From: [Dave Anderson](#)
To: [Evan Maxim](#)
Cc: [Gordon Ahalt \(gjahalt@gmail.com\)](#); [anderson9200@comcast.net](#); [londonimplant@gmail.com](#); [robertroyalgraham@gmail.com](#); [robin@sammgroup.com](#); [vduchaine@comcast.net](#); "Rick Duchaine"
Subject: MI Treehouse SEPA Review 5637 East Mercer Way, Mercer Island, WA 98040
Date: Sunday, December 1, 2019 4:06:59 PM

From: [Dave Anderson](#)
To: [Evan Maxim](#); [gjahalt@gmail.com](#)
Cc: [anderson9200@comcast.net](#); [londonimplant@gmail.com](#); [robertroyalgraham@gmail.com](#); [robin@sammgroup.com](#); [vduchaine@comcast.net](#); "Rick Duchaine"; [Bio Park](#)
Subject: RE: CAO15-001; SEP15-001; VAR18-002; Treehouse SEPA Review 5637 East Mercer Way, Mercer Island, WA 98040
Date: Friday, October 4, 2019 11:33:51 AM

DATE 12-1-2011
 09-25-2018
 10-23-2019
 PROJECT NO. 001
 SHEET NO. 1

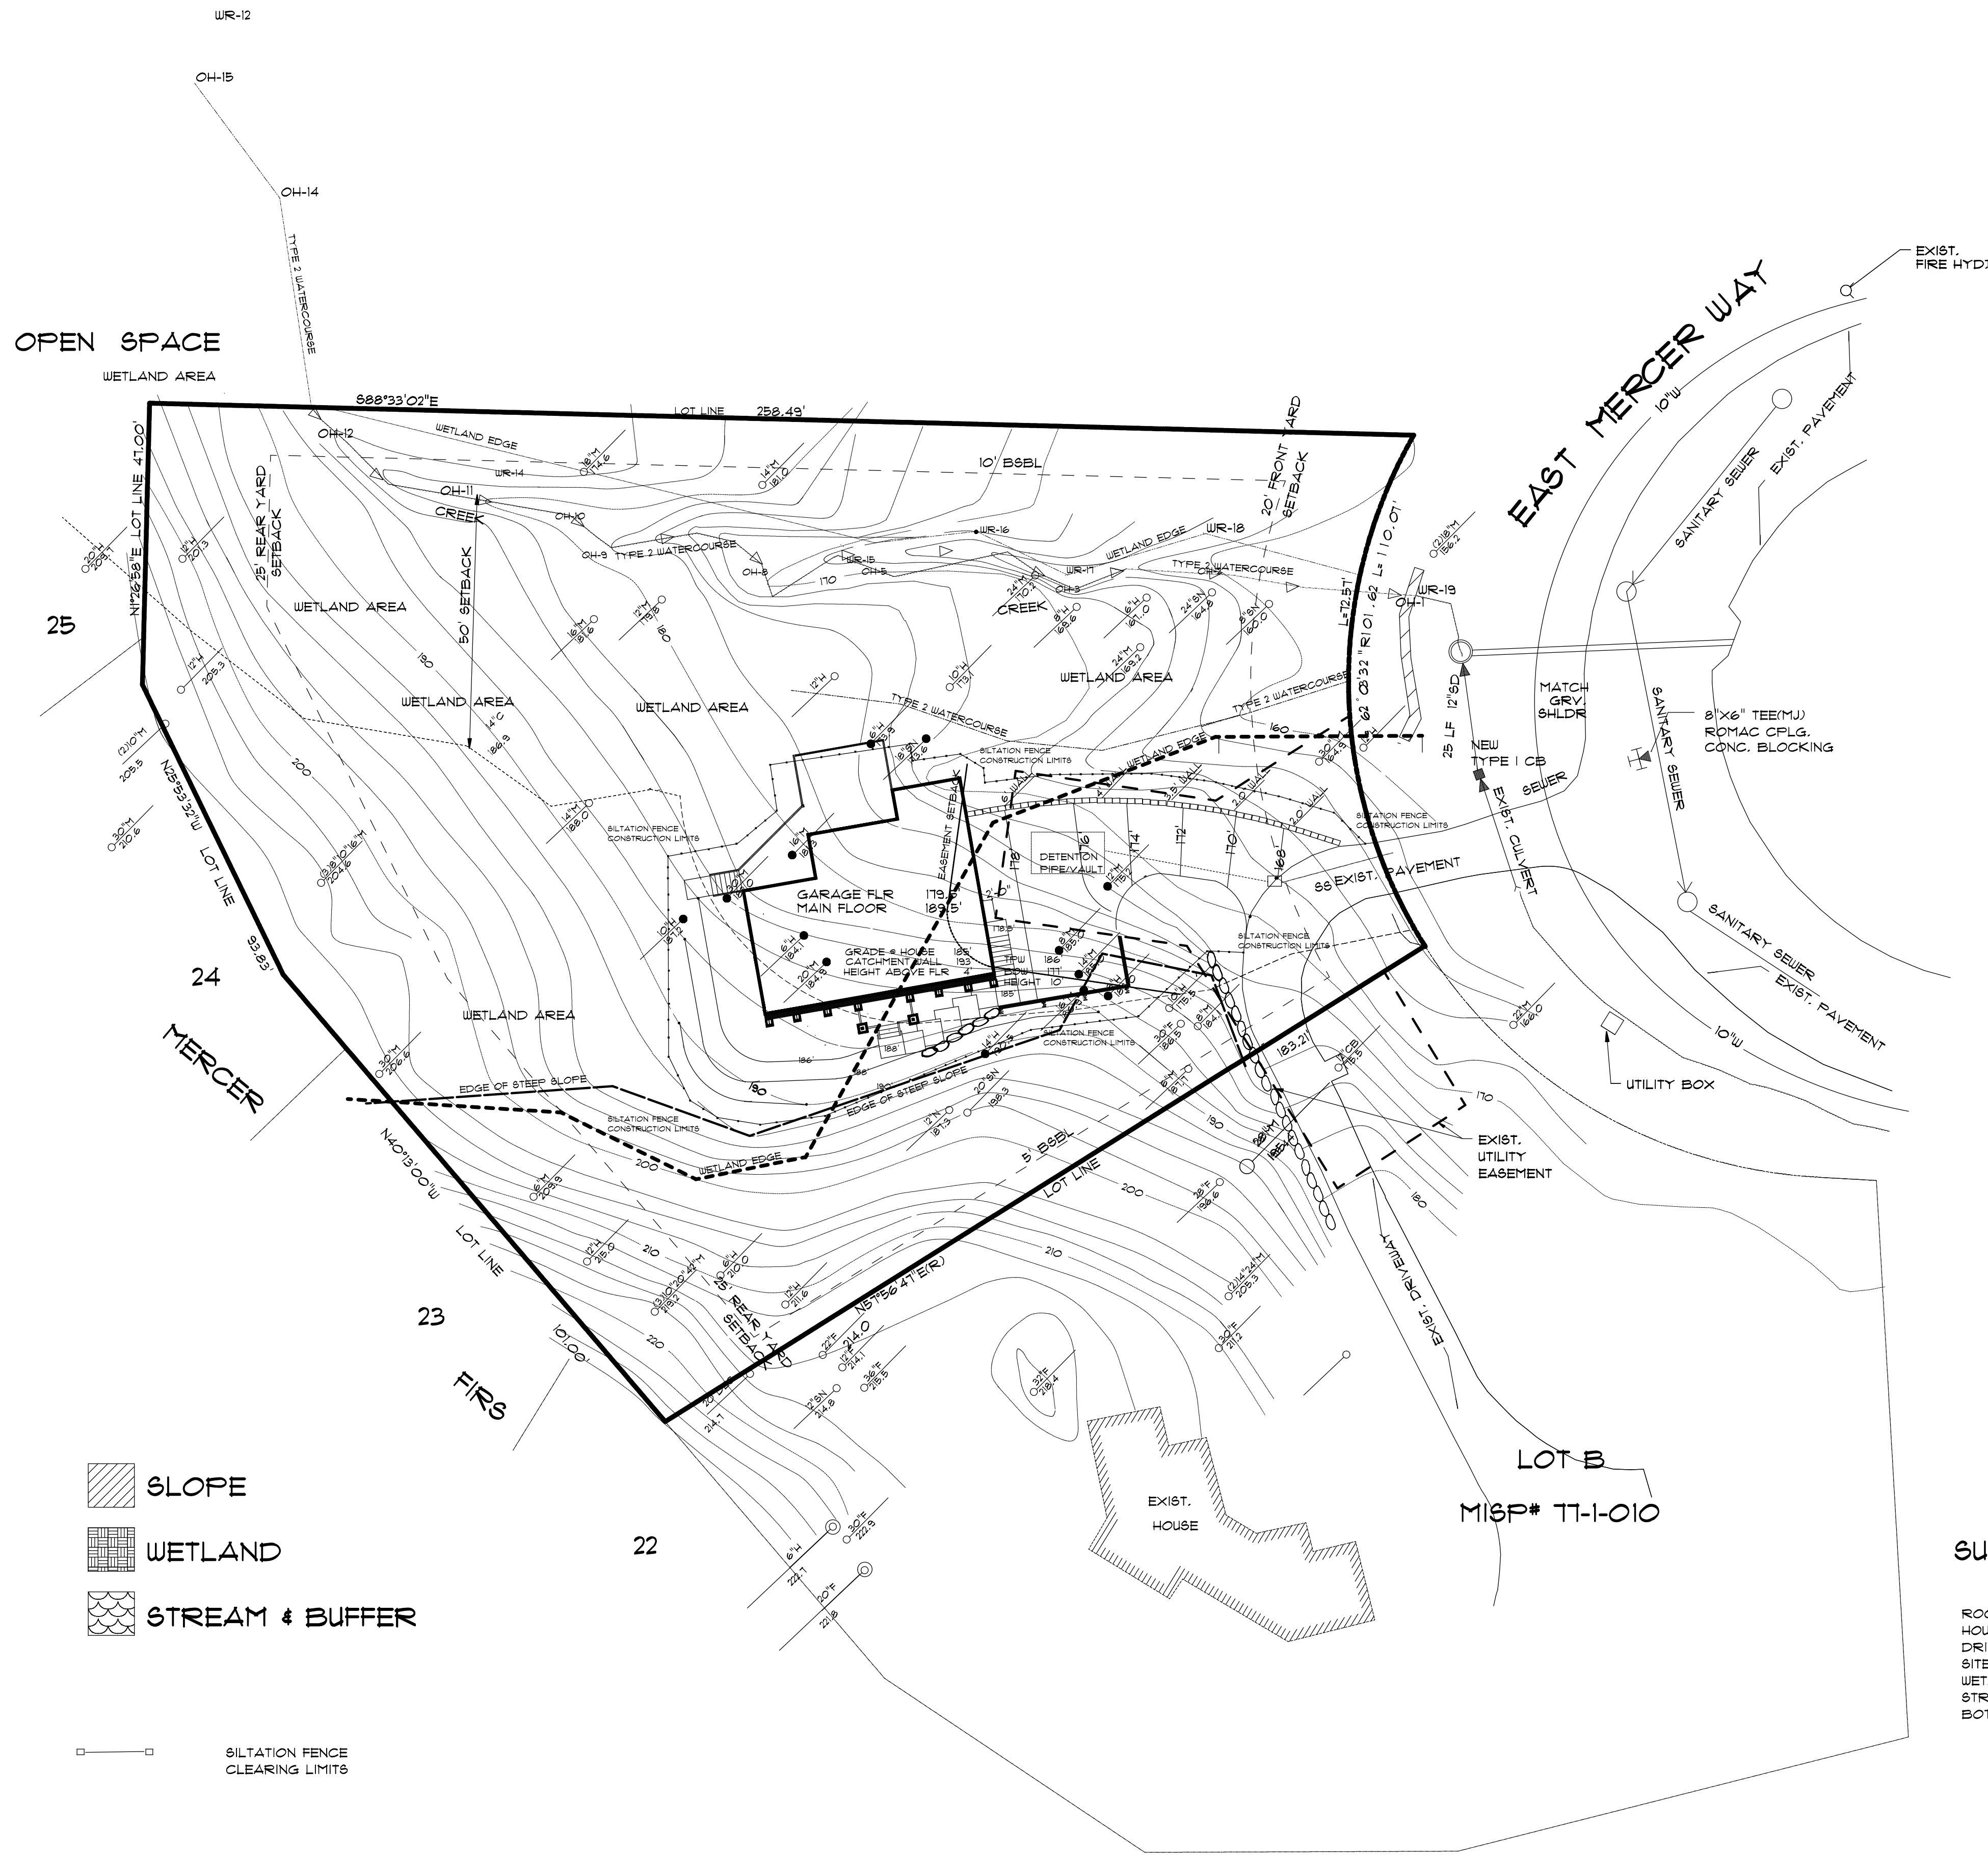
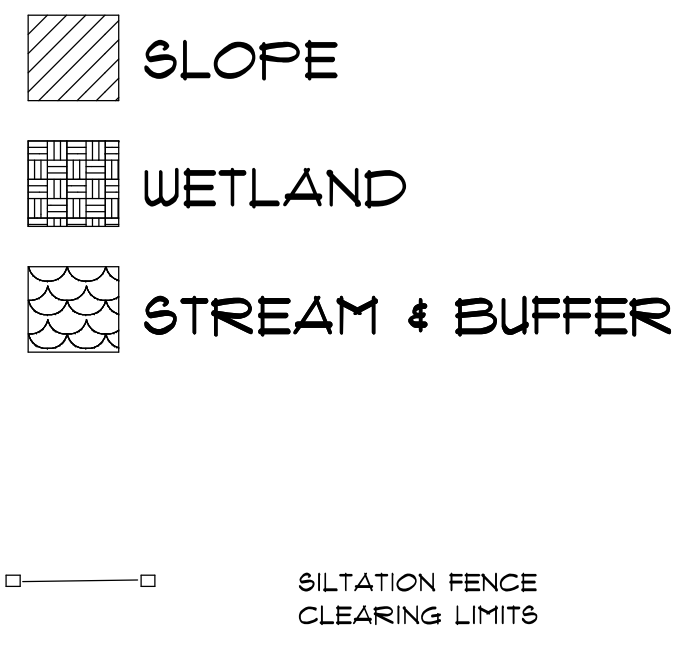
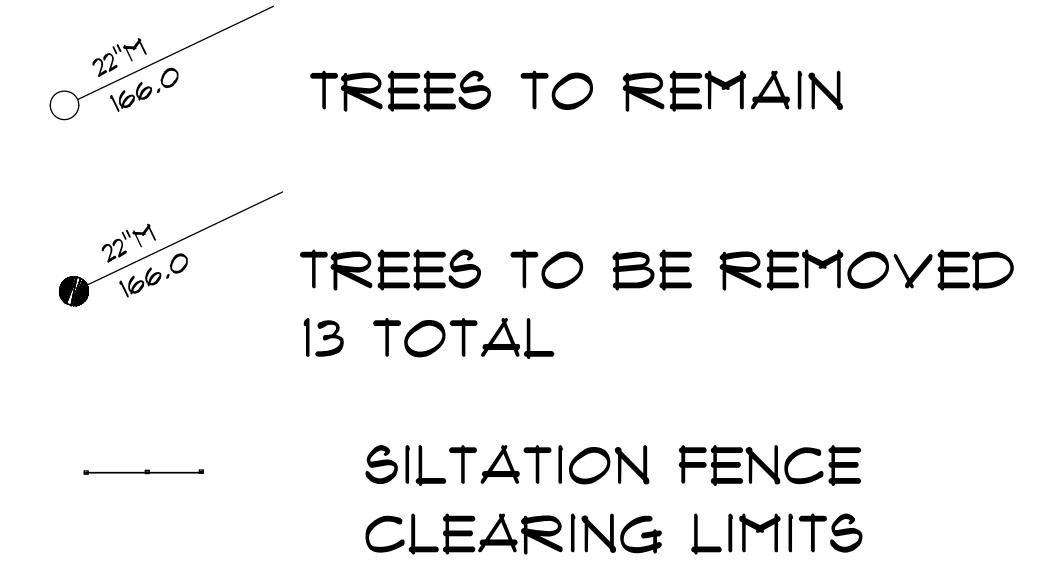
It is my understanding that the foundation drainage system including that associated with the proposed retaining wall will be approximately 10 feet below the existing wetland elevation. This is required to prevent hydraulic forces associated with the ground water from applying pressure on these walls. This will require the perched water table elevation to be lowered to below an approximate elevation of 178 feet (at least 18 inches below the garage elevation of 179.5). Much of the water intercepted by these drains would be seeping out of the wetland slope into the existing type 2 watercourse. The movement of this water through a pipe will be quicker and more efficient than this seepage. As the existing sandy soils are very wet or saturated, lowering the perched water table elevation will almost certainly impact the adjacent upland wetland areas. Given the drainage characteristics typically associated with sandy outwash soils and that these soils are currently saturated, the impact to could extend quite some distance to the west. The site plan and the associated disturbed wetland areas still do not reflect or account for these impacts that will be permanent.

Please note that the recommendations included in Section 5.6 of the geotechnical report for drainage are also not acknowledged on the site plan or in the tabulated areas of wetland disturbance. This includes a recommendation to slope the ground surface away from the proposed building at a gradient of at least 3% for a distance of at least 10' away from the building for all areas that are not paved. This would include grading and surface impacts to the existing wetland areas south and west of the building site.
